From: Martyn White
Sent: 20 November 2018 10:13
To: Anita Gardner
Subject: CM/26/18/L

CM/26/18/L

The application seeks to undertake sympathetic works to the roof of the Mill. Further it also proposes to undertaken a small section of rebuilding to the northern gable to enable roof to be reinstated over exposed verges; as well as specific repointing where brickwork is defective; repointing of chimney stacks using the correct mortar.

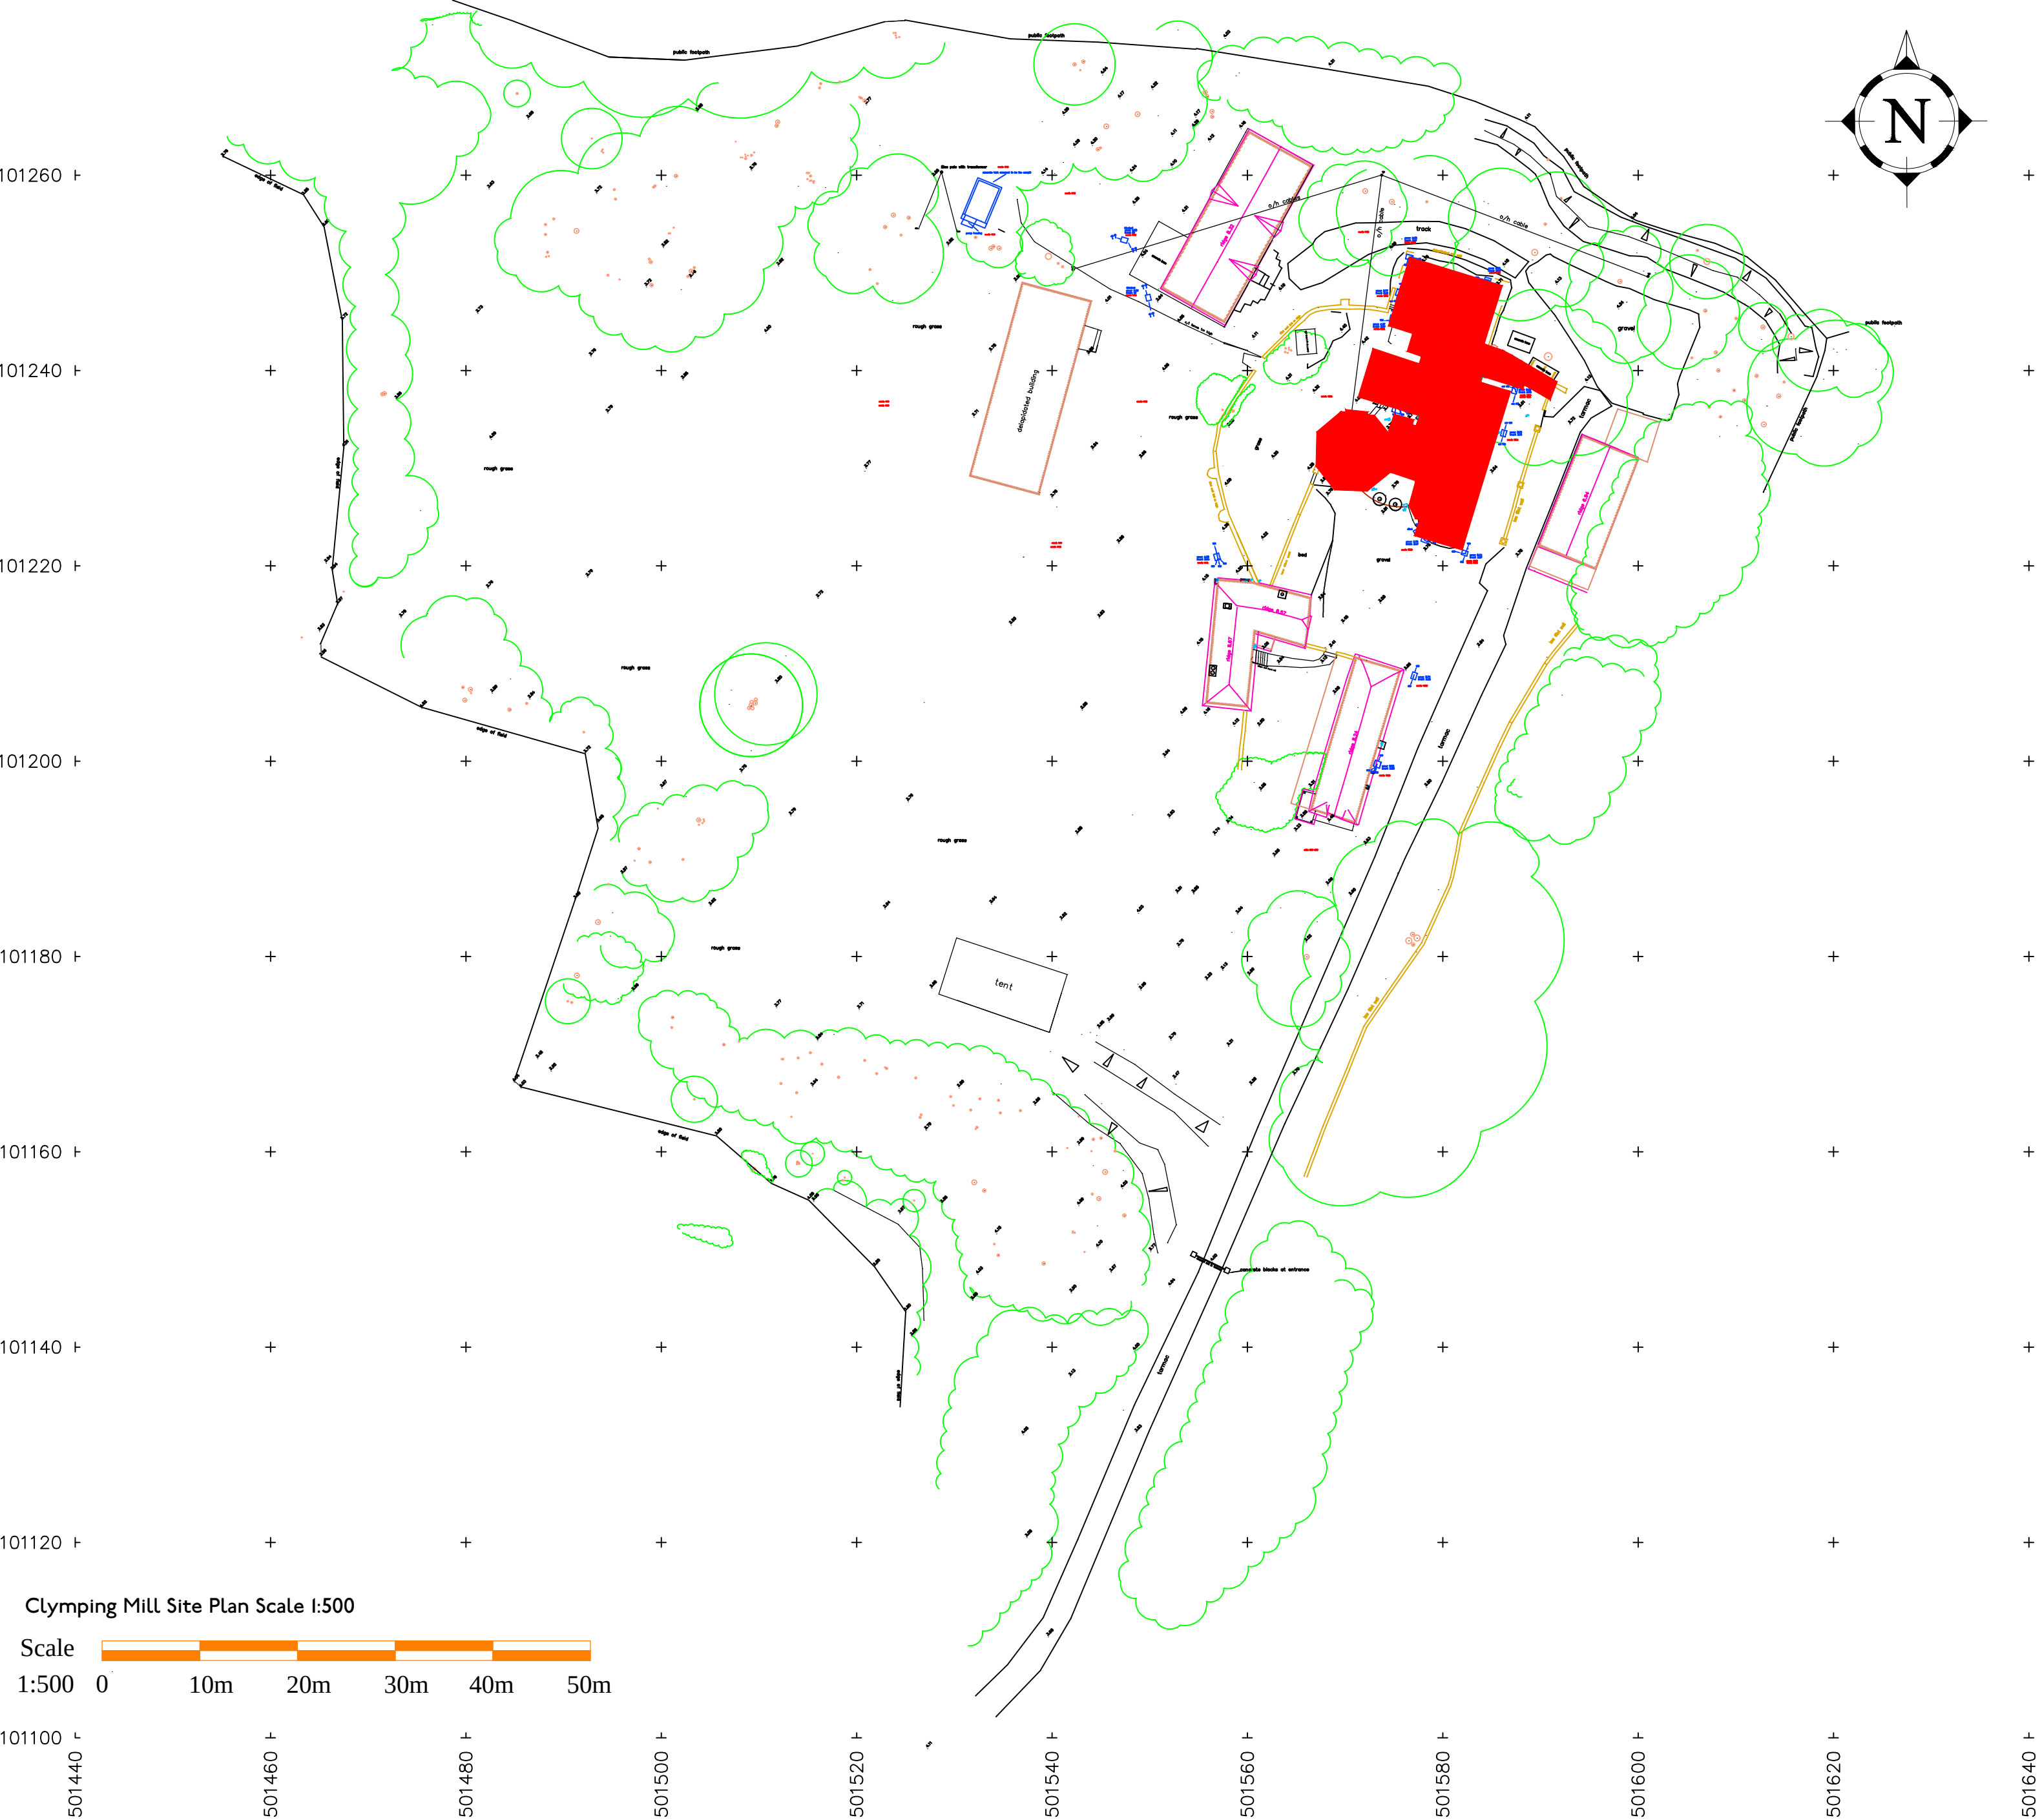
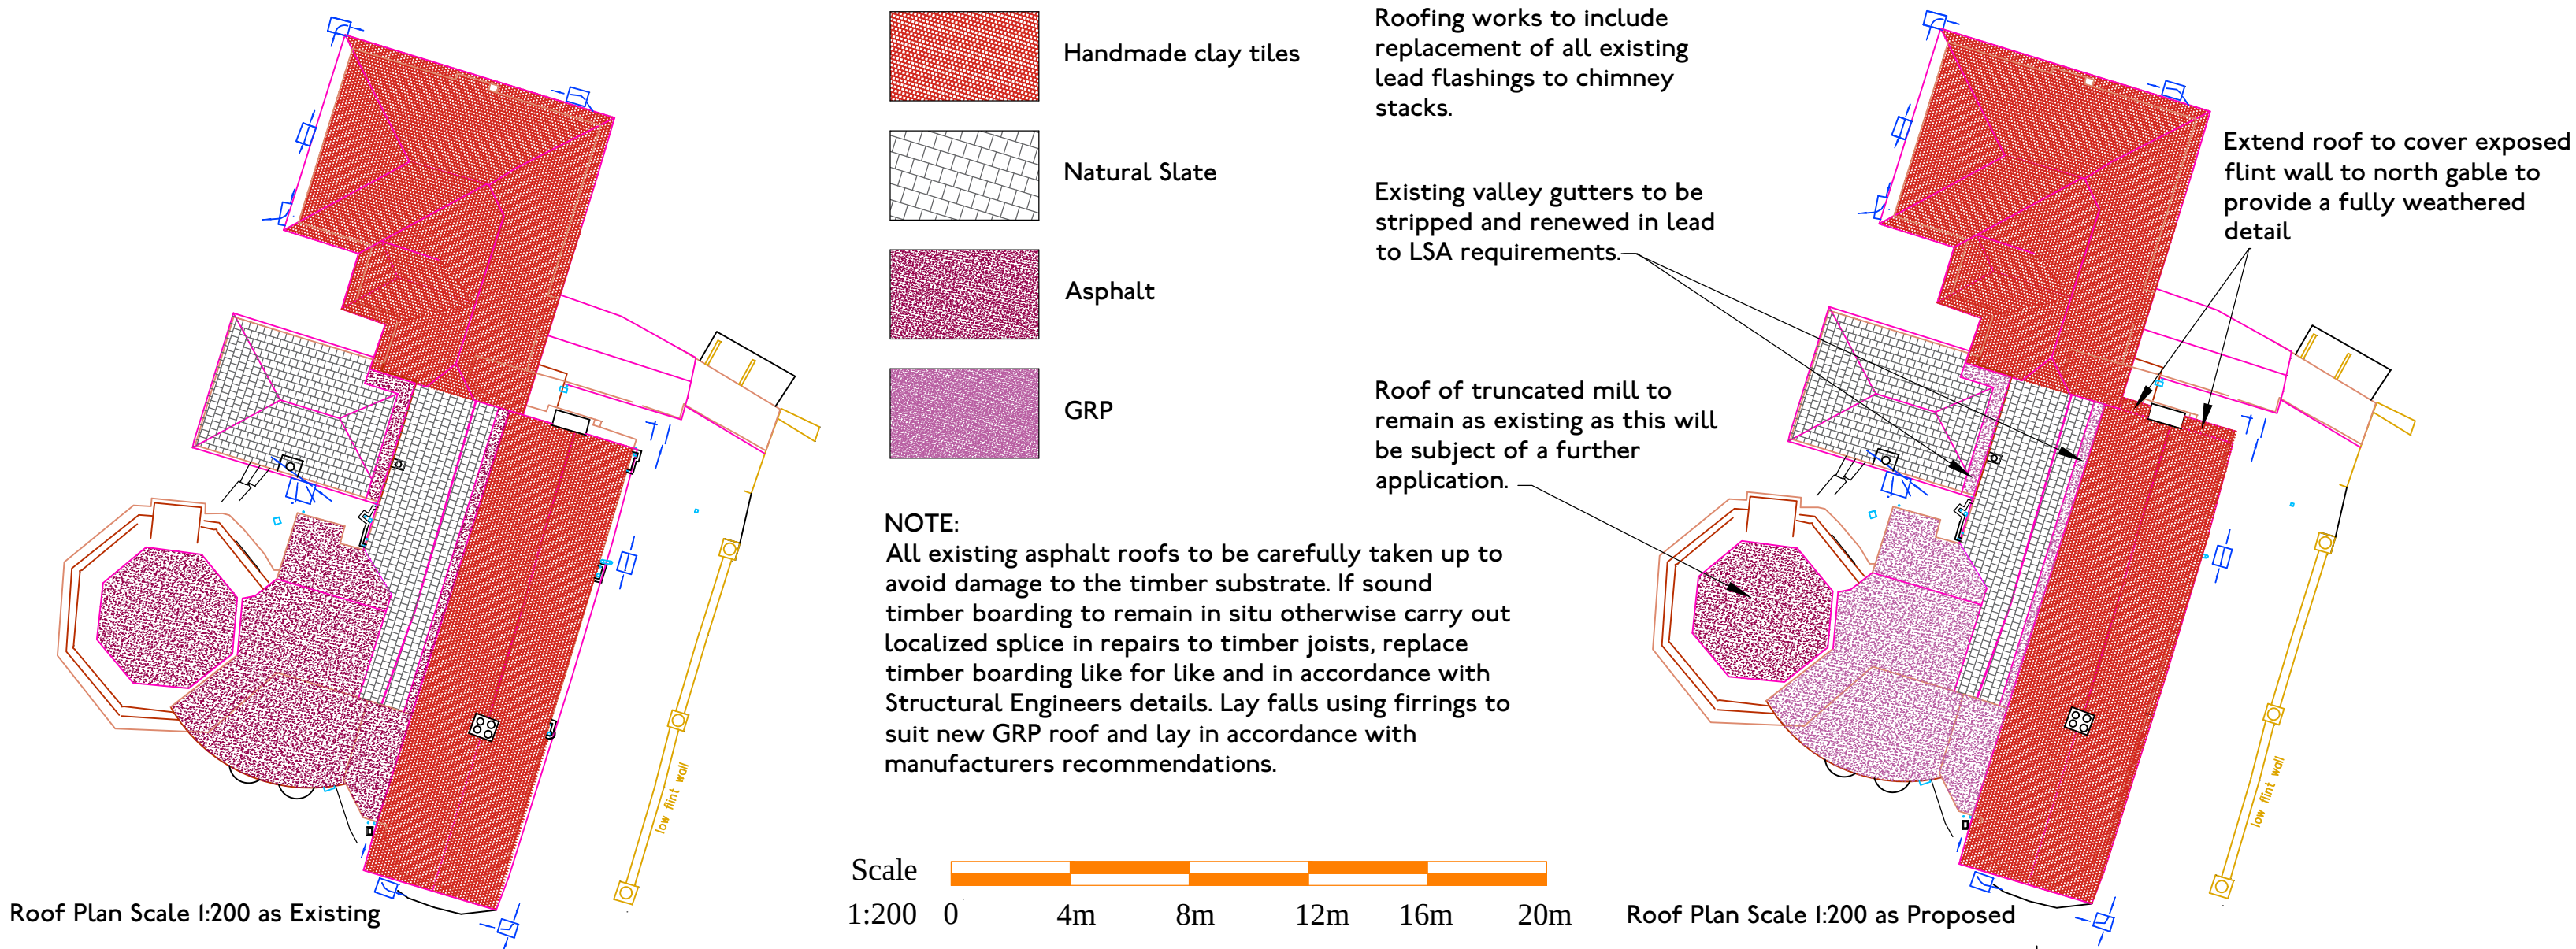
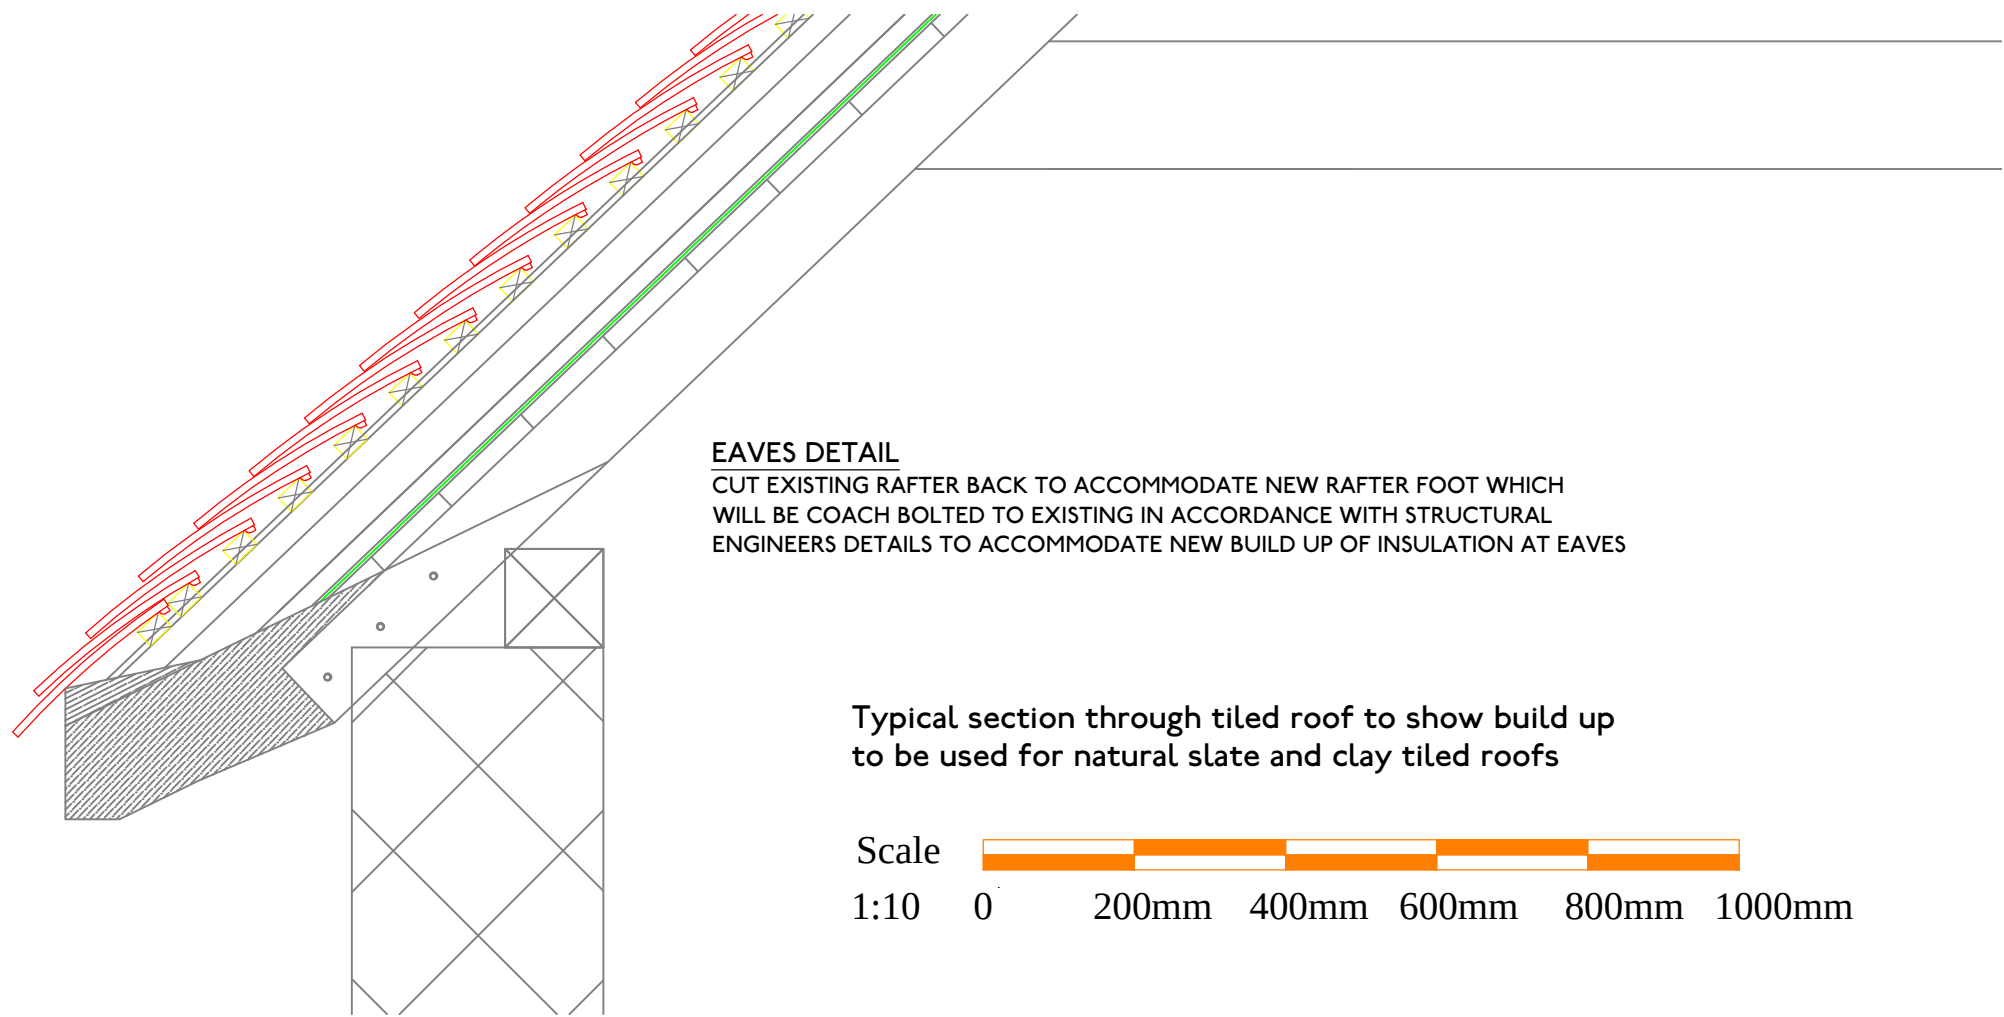
I note that the application seeks to retain all traditional roofing materials where in a good state for re-use. Such a proposal is supported. Mortar will be prepared in accordance with the existing traditional material located on the building. all works should be undertaken in order for the building to be able to satisfactorily breath.

You may wish to condition the details of the slate/clay tile, along with the replacement rainwater goods, and details of the works to the northern gable which will extend the roof to cover the exposed flint wall.
